Morecambe Offshore Windfarm: Generation Assets Examination Documents

The Applicant's Response to ExA's Written Questions 3

Document Reference: 9.61

8 Liverpool Bay SPA with 2.4nm CPP1 WTG and OSP Aviation Buffer and 2.4nm Calder WTG and OSP Buffer

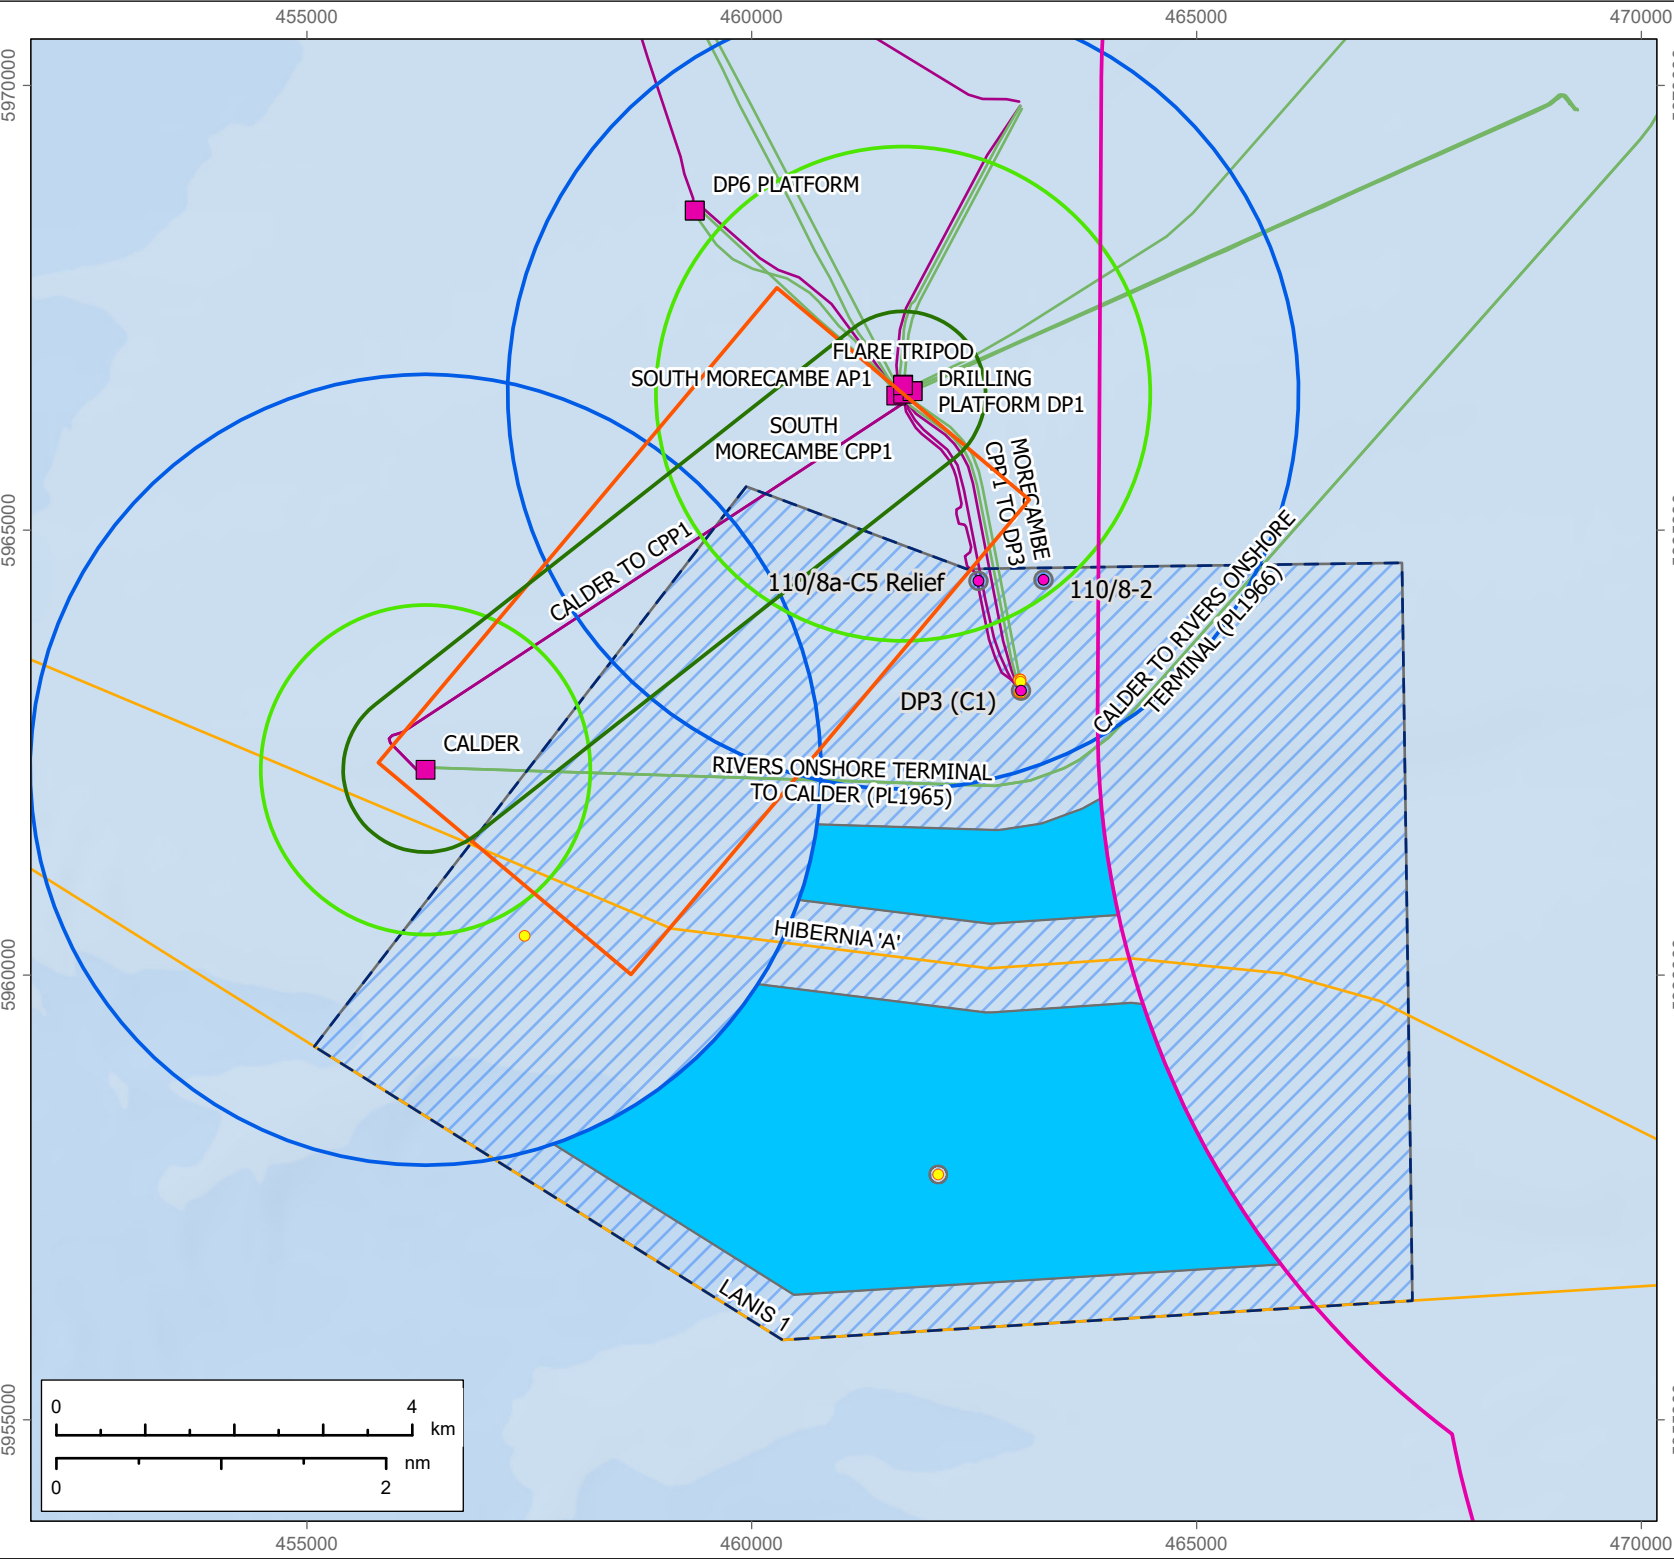
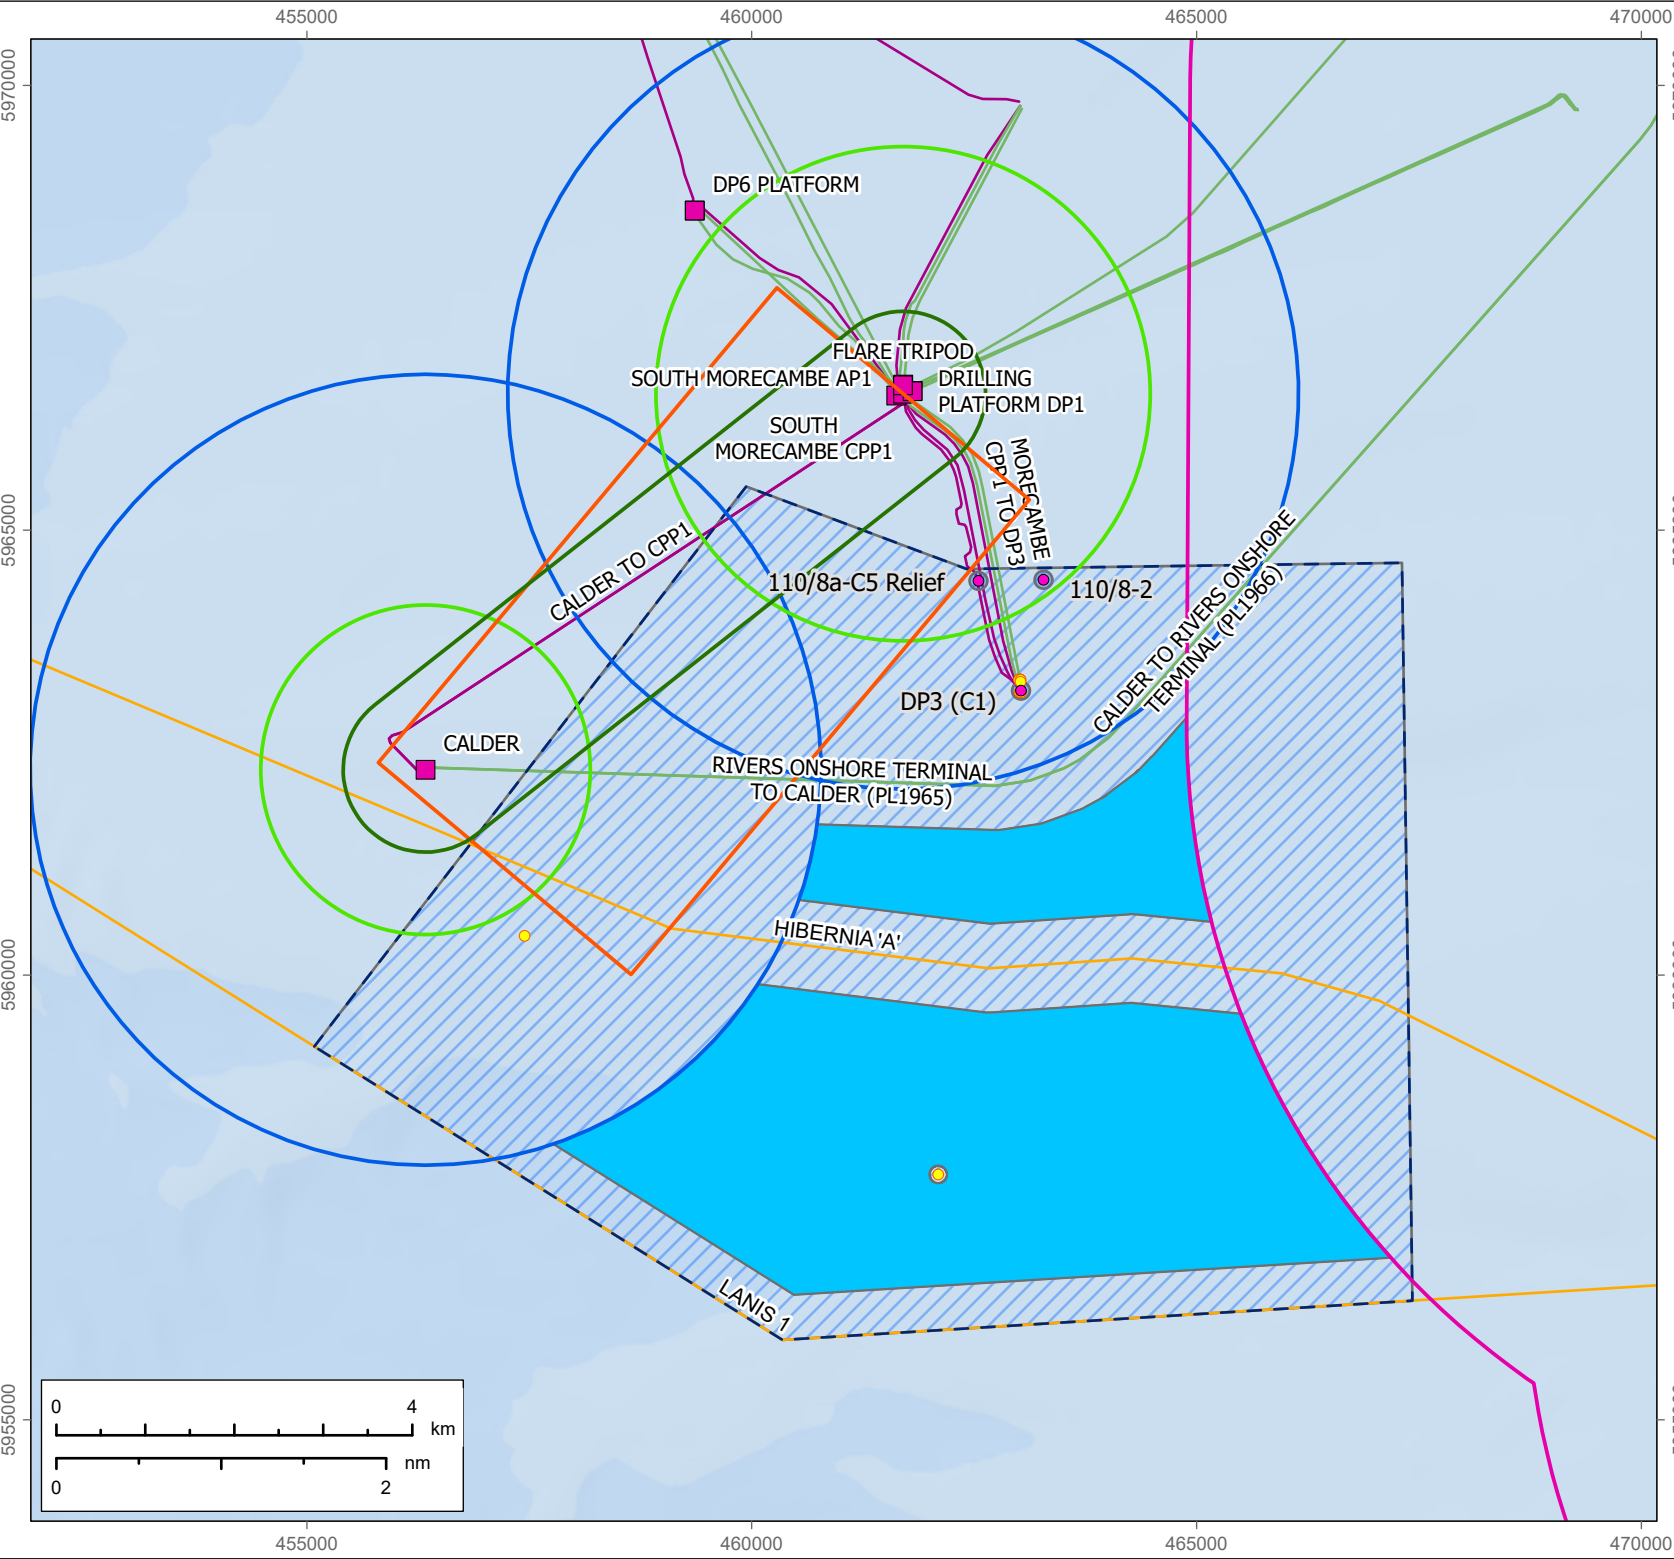
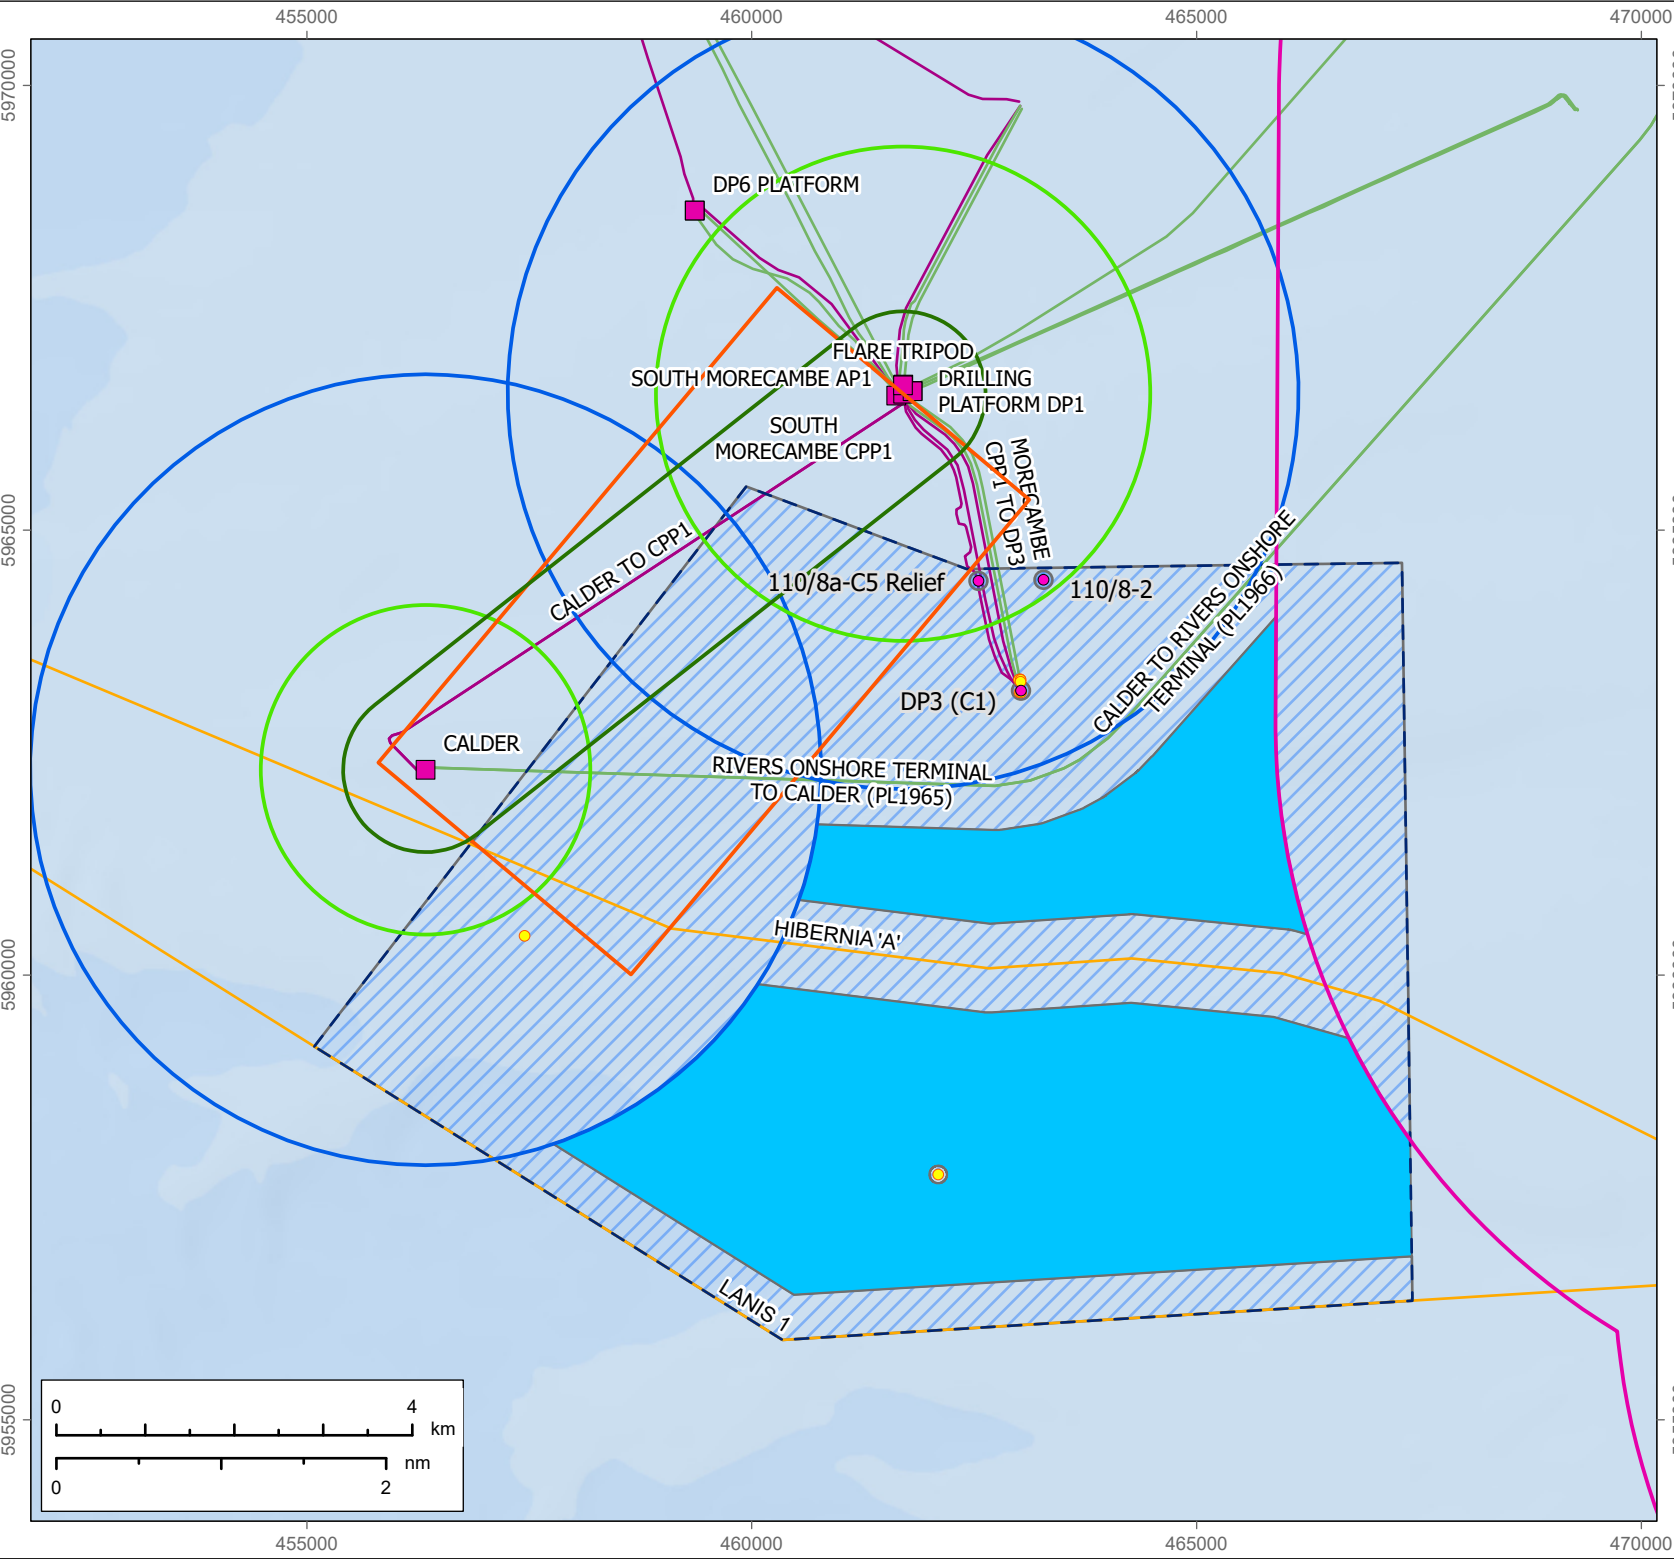
Ref.	Question to:	Question	Applicant's Response										
		<p>b) in Spirit Energy's response to ExQ2CAR5 at D5 [REP5-090] it advises a buffer distance of 1.9nm is the minimum acceptable requirement for safe landing and take-off in daytime VMC and for night VMC this distance would be 2.4nm. In light of this could the applicant provide plans for each alternative SPA buffer scenario in (a) plus each of the increased buffer scenarios from the Calder and CCP1 platforms as set out in the following table.</p>

<p>c) any additional comments or further information the applicant wishes to provide on the implications of each of the above scenarios (noting the applicant's previous response [REP5-070], EXQ2HRA3 and 2HRA6].</p> <p>The ExA is seeking a complete set of alternative scenarios shown on plans, so that, whatever the SoS may determine, if they felt it was appropriate they could include the relevant plan within any final DCO without having to revert to the applicant for that plan. Each should therefore have a different drawing number.</p>	<u>CPP1 WTG and OSP Aviation Buffer</u>	<u>Calder WTG and OSP Buffer</u>	1.9nm	1.9nm	2.4nm	1.9nm	1.9nm	2.4nm	2.4nm	2.4nm	
<u>CPP1 WTG and OSP Aviation Buffer</u>	<u>Calder WTG and OSP Buffer</u>												
1.9nm	1.9nm												
2.4nm	1.9nm												
1.9nm	2.4nm												
2.4nm	2.4nm												
3GEN4	The applicant	<p>Design Statement - Cabling</p> <p>Could the applicant please explain why (former) provision DC15 relating to use of the most direct/ efficient cabling</p>	<p>The Applicant removed the former provision DC15 as it considered that this was duplication of DC10. The Applicant has updated the Design Statement_Rev 04</p>
